**Submission to the the Woolgoolga to Ballina Pacific Highway Upgrade Project
Modification 4 - Moonimba Quarry Development Application Modification**

Thank you for the opportunity to comment on this proposed modification to the Moonimba Quarry consent.

This submission is being made to ensure the emergency services contractors have continued, unimpeded access to the radio site during the quarrying activities and an access management plan so as access can be managed around blasting and other site activities that might restrict maintenance/construction access.

ACMA Licenced
Communication
Facilities

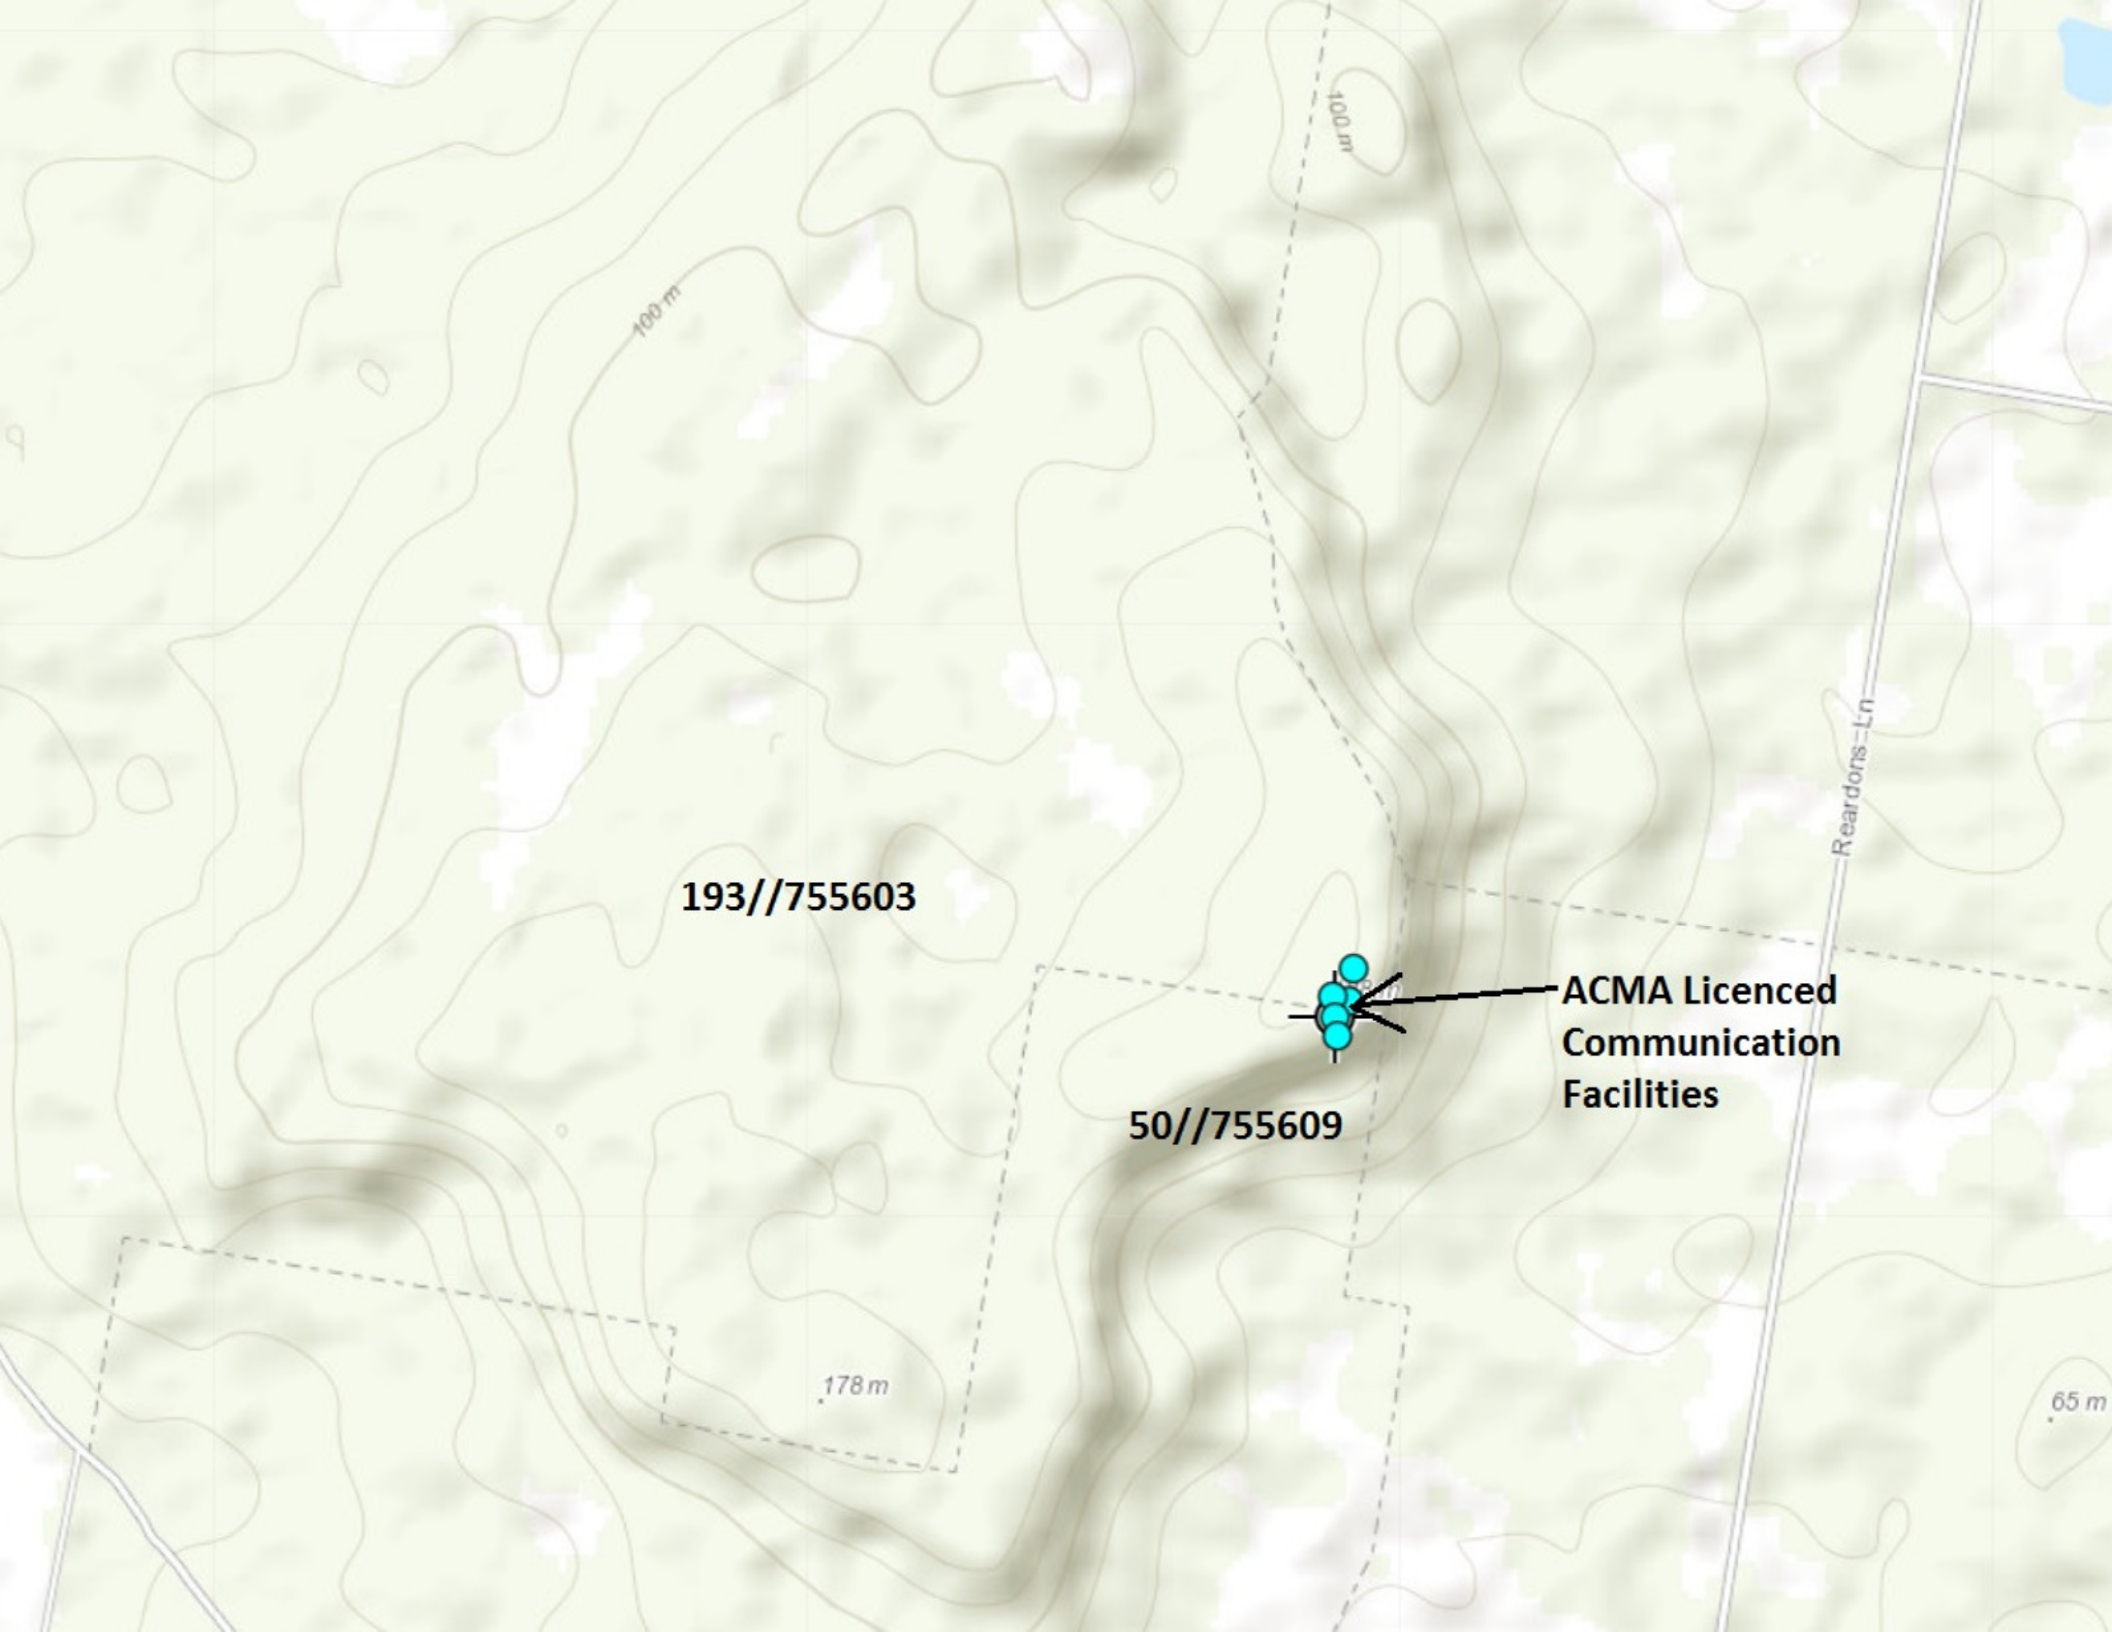
I write I regard to Moonimba Quarry Development Application Modification, being lot 193 DP 755603. Currently, there is located a number of strategically important Communications Facilities, that cover the local area and a large stretch of the Pacific Highway. These Communication sites are as follows:

- ACMA ID: 202159 - Moonimba Trig off Boggy Creek Road
- ACMA ID: 135328 - Optus Site Woodburn Boggy Creek Road WOODBURN
- ACMA ID: 139958 - 2RBR Broadcast site Boggy Creek Road MOUNT MOONIMBA NSW 247
- ACMA ID: 280226 - Vodafone Site MOUNT MOONIMBA NSW 2471

Current Access to
Communication
Facilities

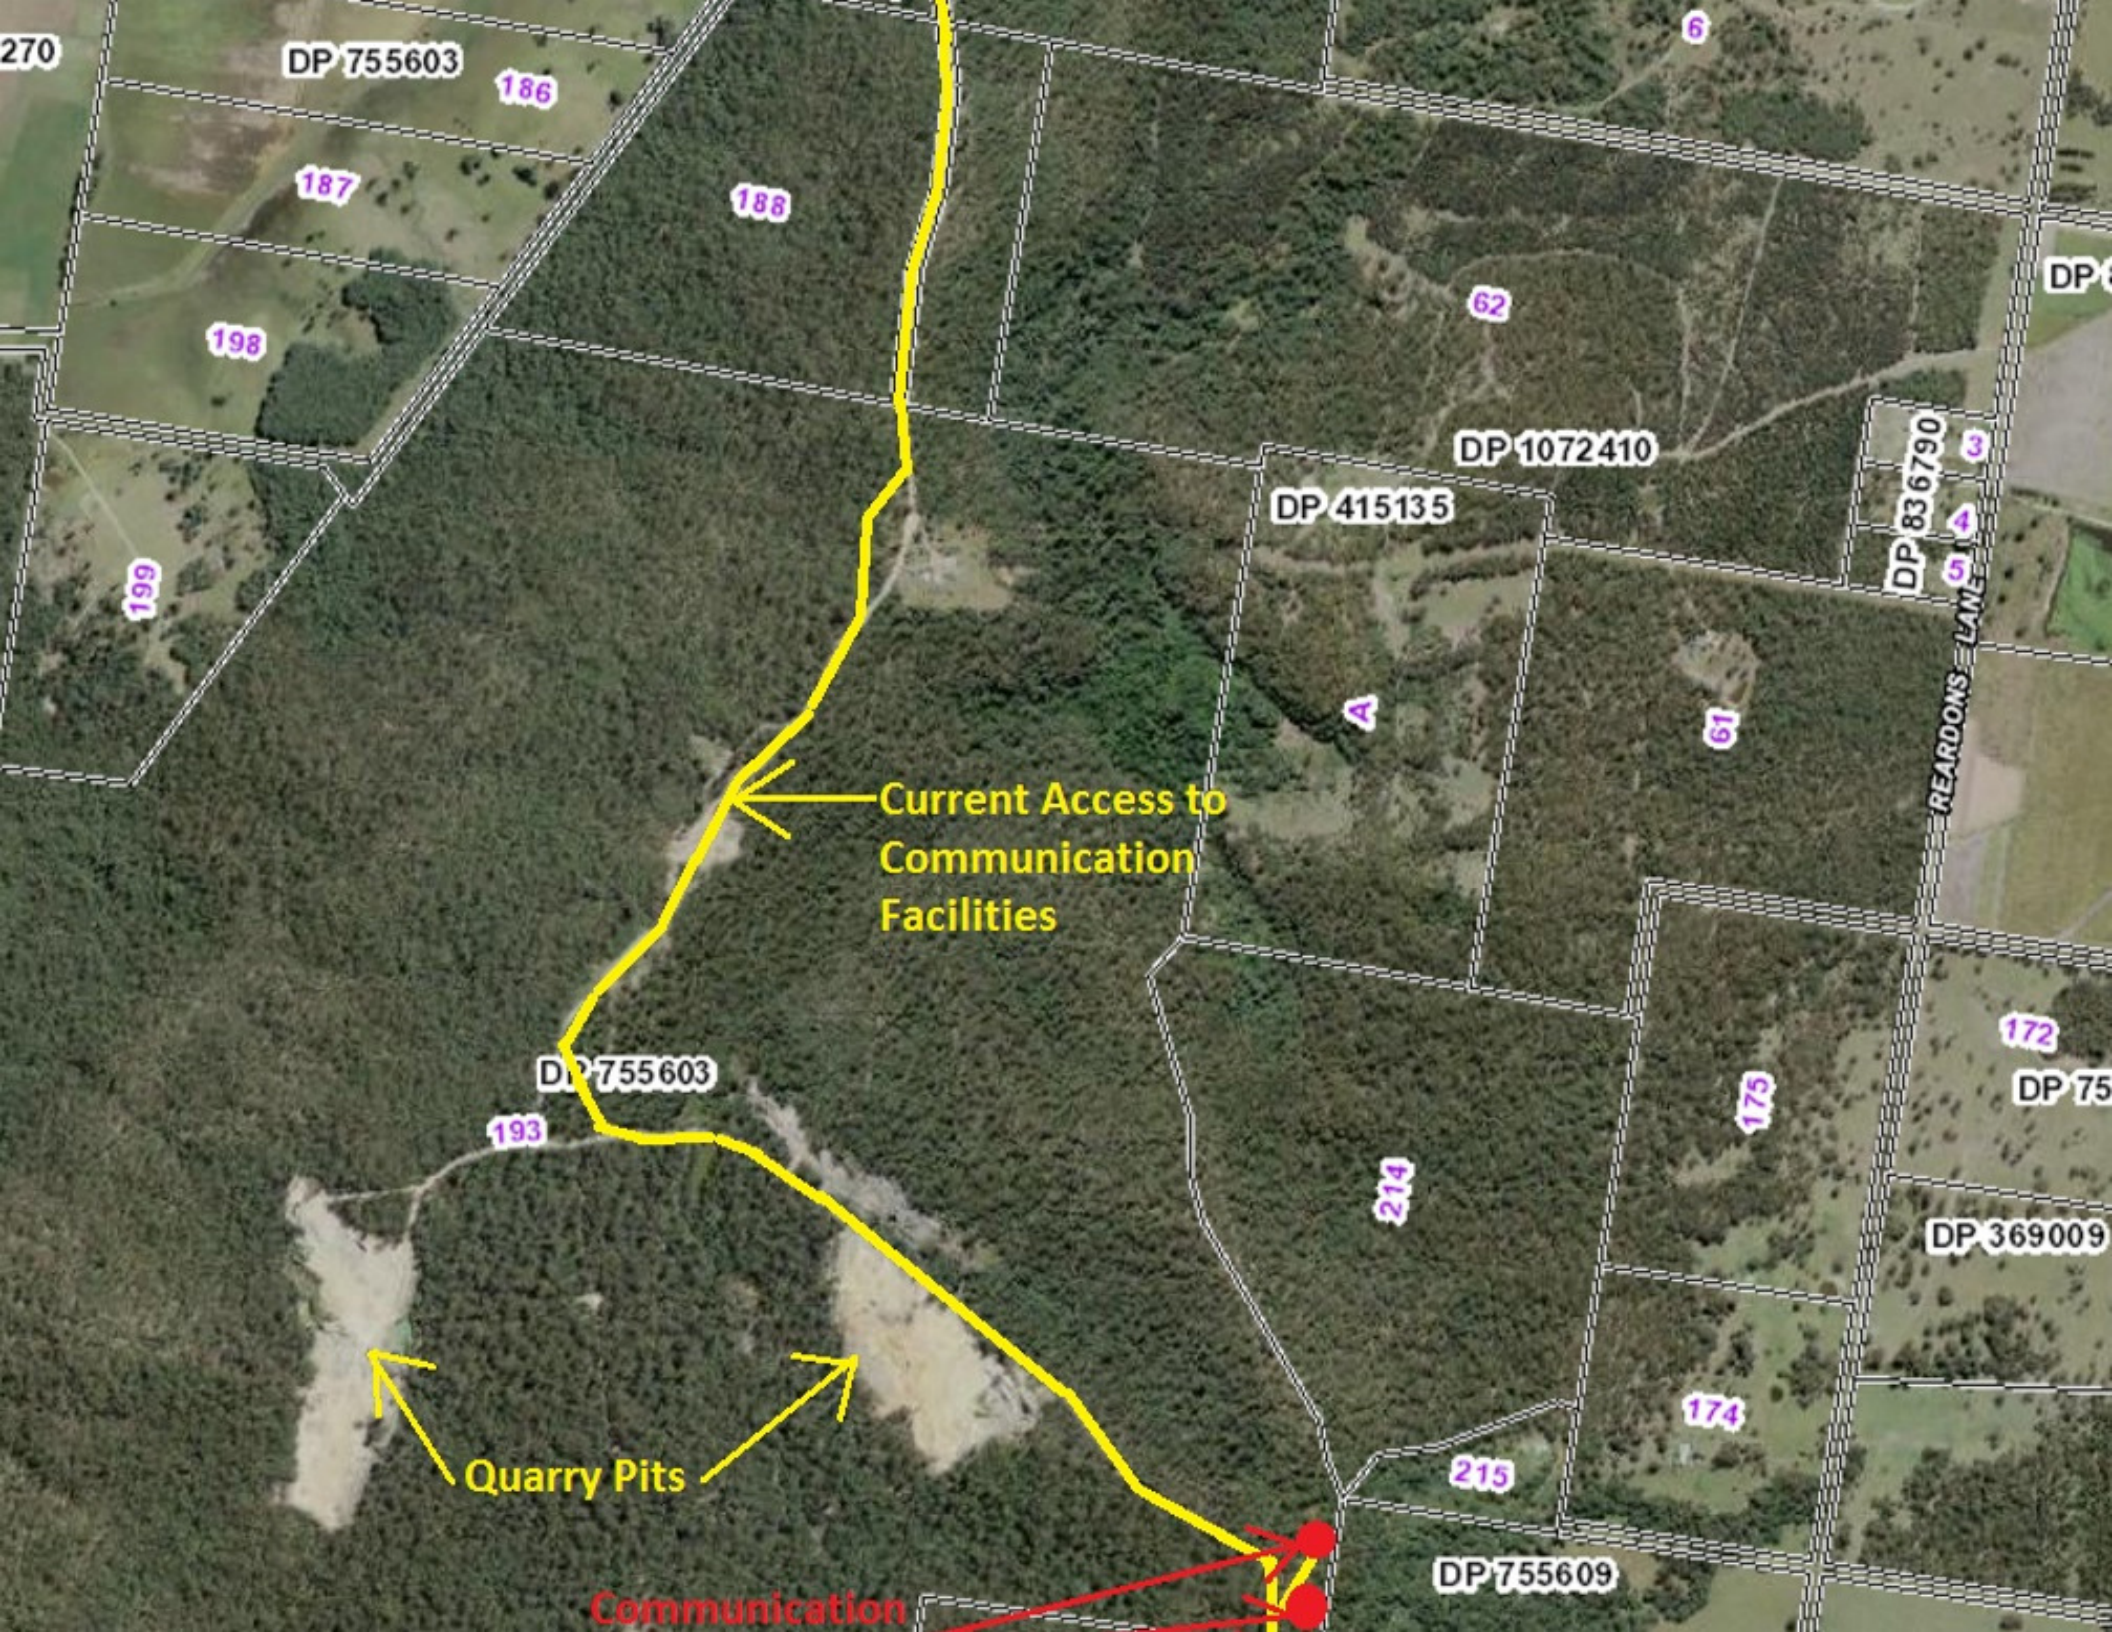
Please see the attachment for existing access route for the emergency services and telco carriers.
